# KIRKLEES METROPOLITAN COUNCIL INVESTMENT & REGENERATION SERVICE

| Reference No:         | <b>2024/62/90757/W</b>                                        |
| Site Address:         | 140, Newsome Road South, Newsome, Huddersfield, HD4 6JJ       |
| Description:          | Erection of single storey rear extension and dormer extension |

Drawn DRH
Date March 2024
Scales 1:100 @ A3
Drawing No. 2417-0301-P02

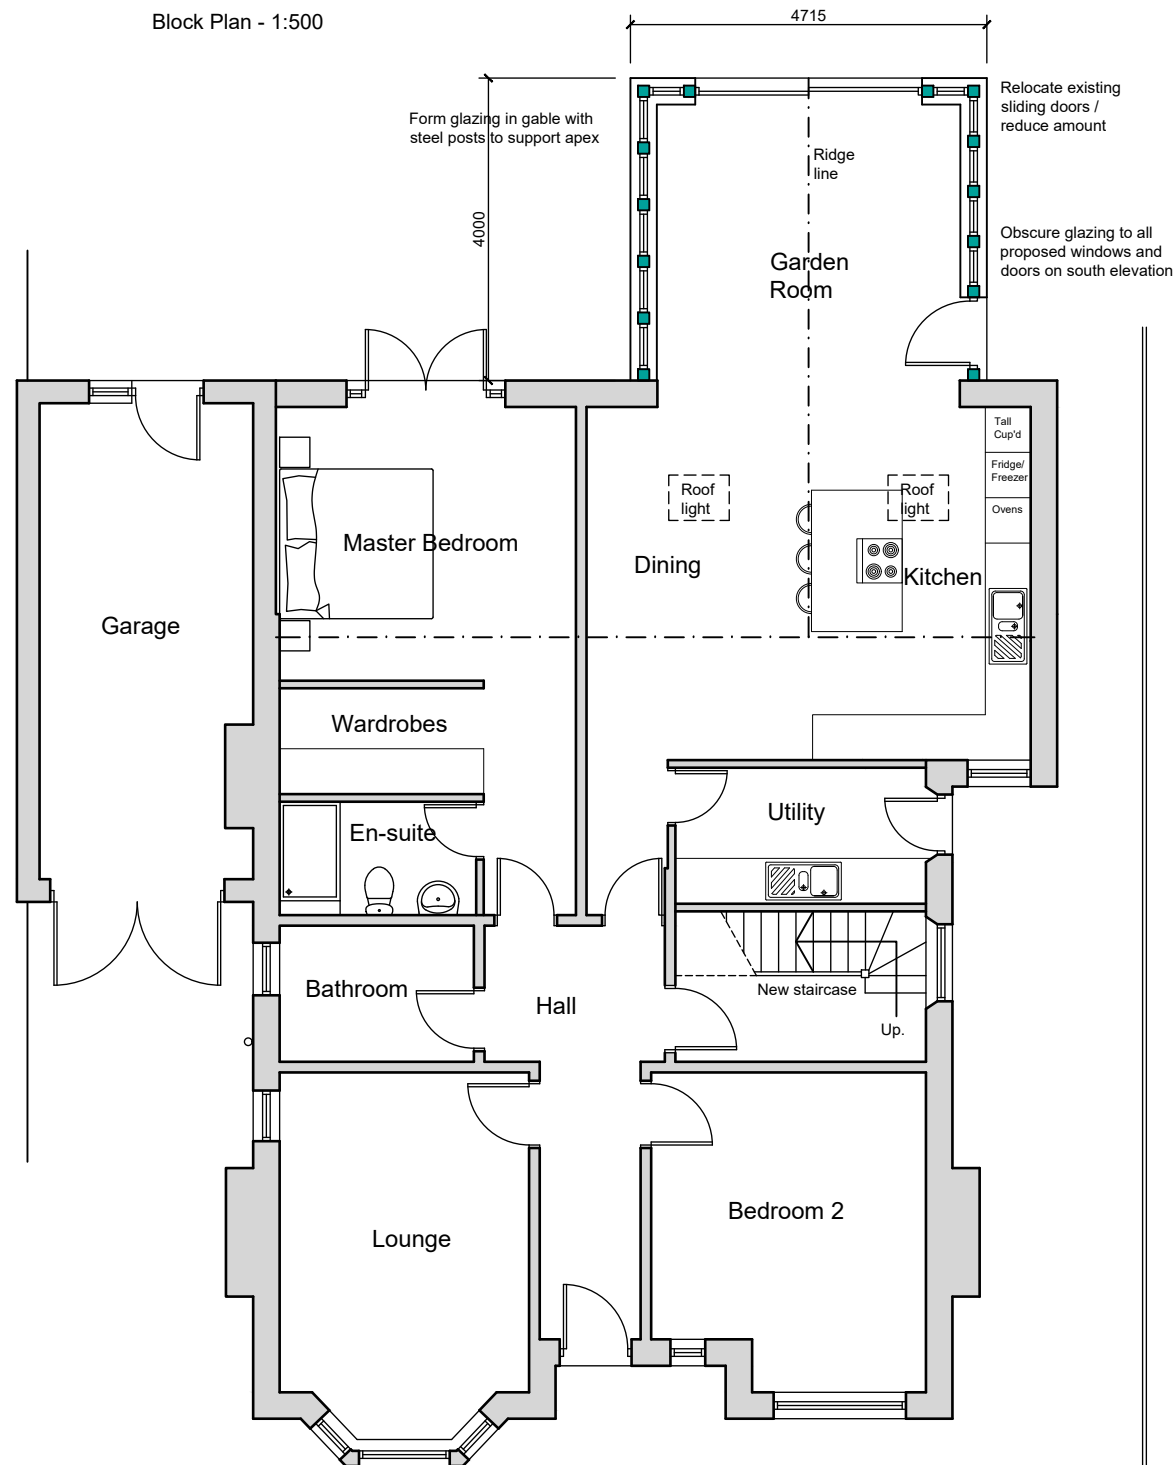
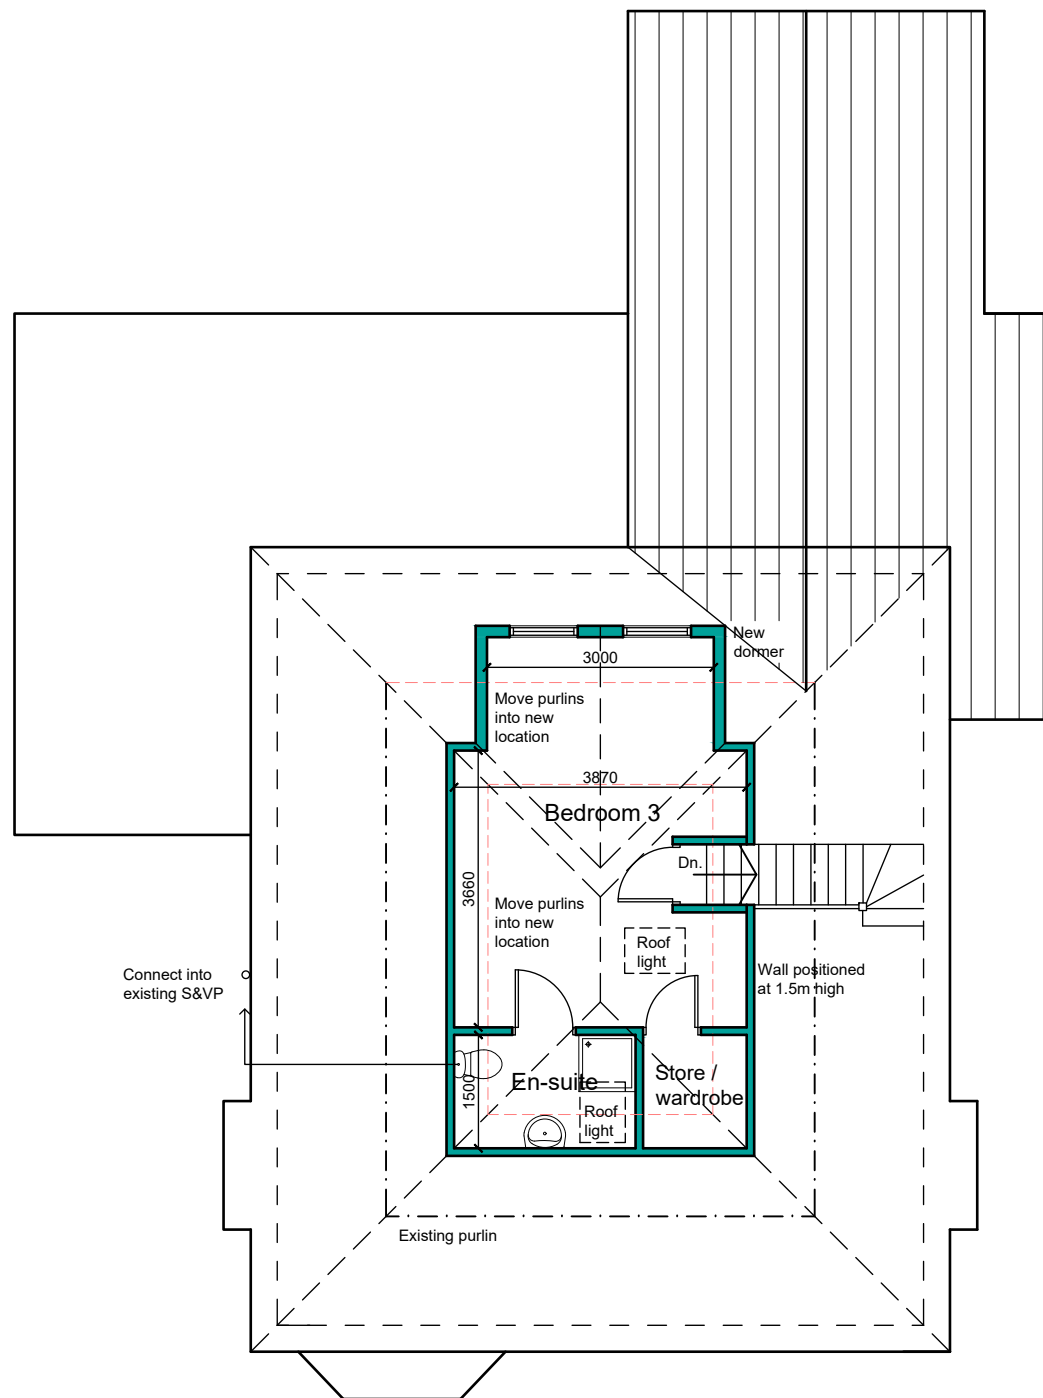
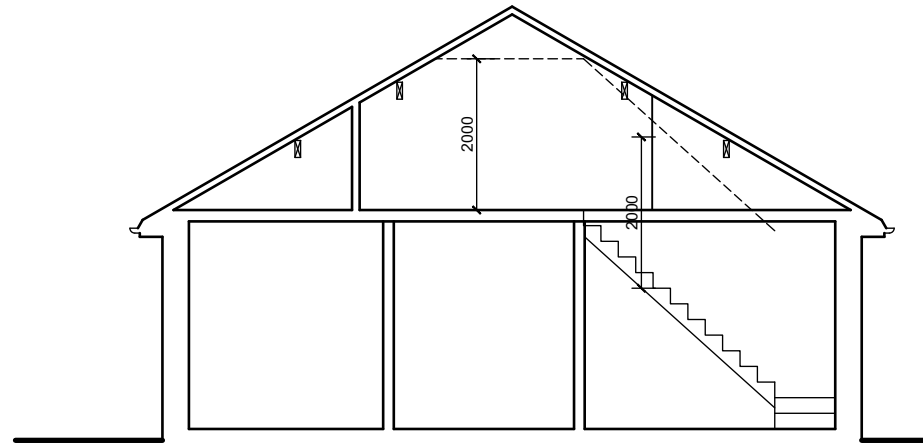
|                                                      | YES / NO | SUMMARY                                                                                                                                                                                                                                                                                                                                                                                                                                                                                                                                                                                                                                                                                                                                                                                                                                                                                                                                                                                               |
|------------------------------------------------------|----------|-------------------------------------------------------------------------------------------------------------------------------------------------------------------------------------------------------------------------------------------------------------------------------------------------------------------------------------------------------------------------------------------------------------------------------------------------------------------------------------------------------------------------------------------------------------------------------------------------------------------------------------------------------------------------------------------------------------------------------------------------------------------------------------------------------------------------------------------------------------------------------------------------------------------------------------------------------------------------------------------------------|
| Negotiations/Amendments during course of application | Yes      | <p>Concerns were initially raised to the agent regarding the cumulative impact of the proposed extensions as the bungalow had been previously extended.</p> <p>The agent was pointed towards the 'comply or justify' principle in the SPD. This states that proposals which depart from the guidance set out in the SPD will need to provide a full justification. The council will be flexible where innovative and contemporary designs which enhance the appearance and character of an area are proposed.</p> <p>and therefore a justification statement alongside this application should be considered.</p> <p>The agent provided a justification statement which will be assessed alongside the proposed plans.</p> <p>It was also considered necessary to require that obscure glazing should be added to the window panels in the south west elevation to limit any direct or perceived overlooking.</p> <p>The agent sent amended plans which will be assessed in the following report.</p> |

The proposed extension will project 4m from the rear wall of the house and will have a width of 4.715m. The extension will have a height to the eaves of 2.5m and an overall height of 4m with a gable roof design. This will create space for a garden room with glazing on 3 elevations. It would be 2.1m from the boundary with no. 142 Newsome Road.

| not project out more than 3 metres from the rear wall of the original house for semidetached and terraces houses or by 4 metres for detached properties |                                                                                                                                                                                                                                                                                             | The house is detached however due to a previous rear extension the projection from the original rear wall will be 7.3m. The agent justified this departure from the SPD by stating 'The additional projection is justified by the limited impact it will have on the neighbour, this is because there is a considerable gap from the boundary of 2.1m, and the height of the eaves is 2.5m, furthermore there is a screen fence to the boundary and a gap of 4.6m from the extension to the neighbours dwelling. Both dwellings benefit from generous gardens, with the distance from |

|                                                                                           |                                                                               | the proposed extension to the eastern boundary being 13.5m.<br>In addition, there is an established precedent for extensions of a similar scale along Newsome Road South. Therefore, on balance this is considered acceptable. This has been considered acceptable in this isolated case based on individual circumstances that might not be material elsewhere. |

|                                                                      | the Kirklees Local Plan and the NPPF                                                                                                                  |                                                                                                                                                                                                                                                                                                                                                                                                                                                                                                                                                                                                     |   |
|----------------------------------------------------------------------|-------------------------------------------------------------------------------------------------------------------------------------------------------|-----------------------------------------------------------------------------------------------------------------------------------------------------------------------------------------------------------------------------------------------------------------------------------------------------------------------------------------------------------------------------------------------------------------------------------------------------------------------------------------------------------------------------------------------------------------------------------------------------|---|
| Impact on privacy of neighbours (to sides, rear and front)           | <ul style="list-style-type: none"> <li>• KDP 3 &amp; 4 of the SPD</li> <li>• Policy LP24 Design (d) (iv)</li> <li>• Chapter 12 of the NPPF</li> </ul> | The justification statement explains the windows have been designed with a limiting width of 460mm. Further to this the ~1.8m fence will screen the proposed extension lessening the impact of the windows on this elevation. Still deemed necessary to have obscure glazing in the south west elevation, as shown on amended plans and controlled by condition. This would limit overlooking. It is therefore considered that this property will not experience any significant impact to their privacy. Around 7.5m from the boundary with no. 138 and this separation would mitigate any impact. | ✓ |

4. The single storey rear extension shall not be first occupied until the door and windows in the south elevation of the extension hereby approved have been first glazed with obscured glass (minimum grade 2). Notwithstanding the provisions of the Town and Country Planning (General Permitted Development) (England) Order 2015 as amended (or any Order revoking or re-enacting that Order) the obscured glazing shall thereafter be retained.
